Please review a plat that as stated in review 1 for the standards. ADD the standard surveyor language above the legal.

URBAN COLLECTION AT PALMER VILLAGE

SITUATED IN THE NORTHEAST QUARTER OF SECTION 5,
TOWNSHIP 14 SOUTH, RANGE 65 WEST OF THE SIXTH PRINCIPAL MERIDIAN,
COUNTY OF EL PASO, STATE OF COLORADO.

DATE OF PREPARATION:	03-19-2020
SCALE:	1" = 60'
SHEET:	3 OF 8

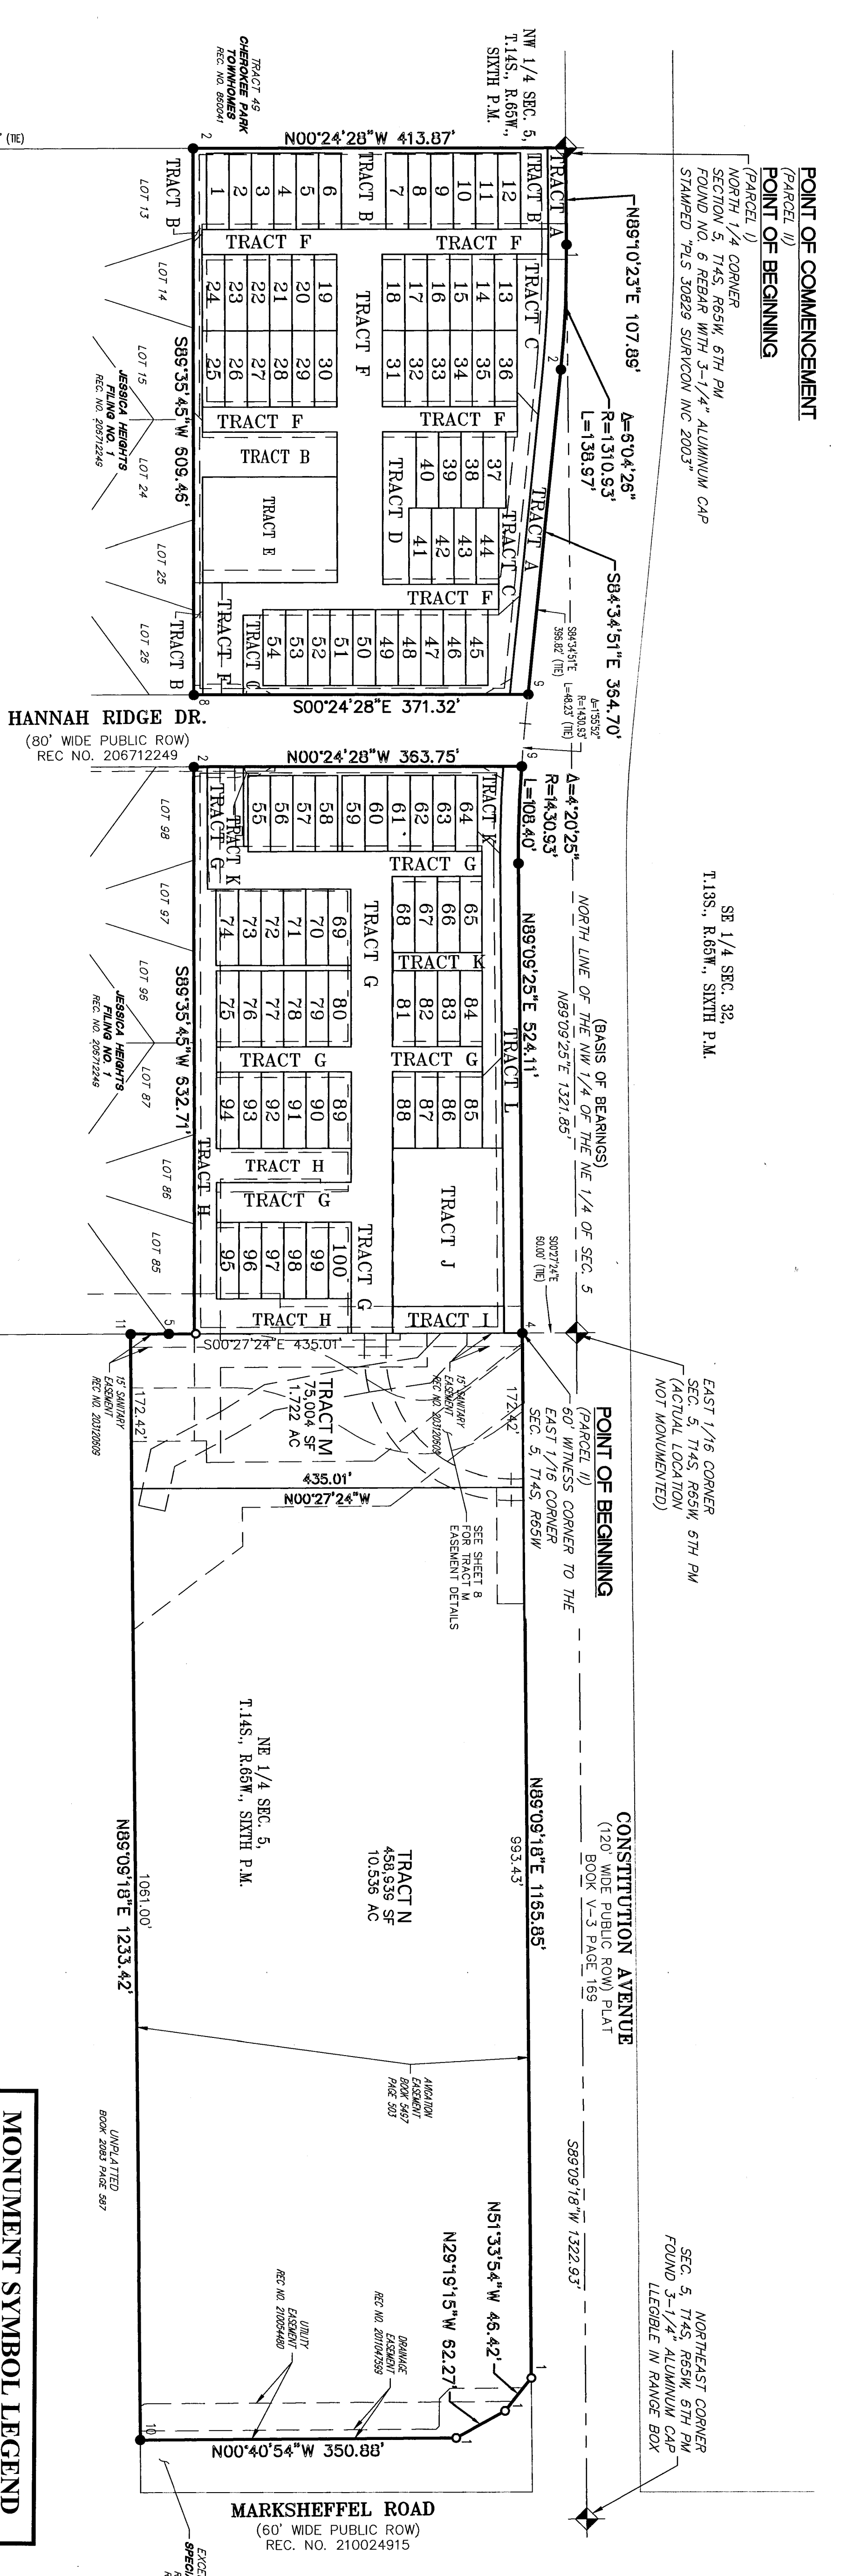
Tract M?

Where is Tract N?
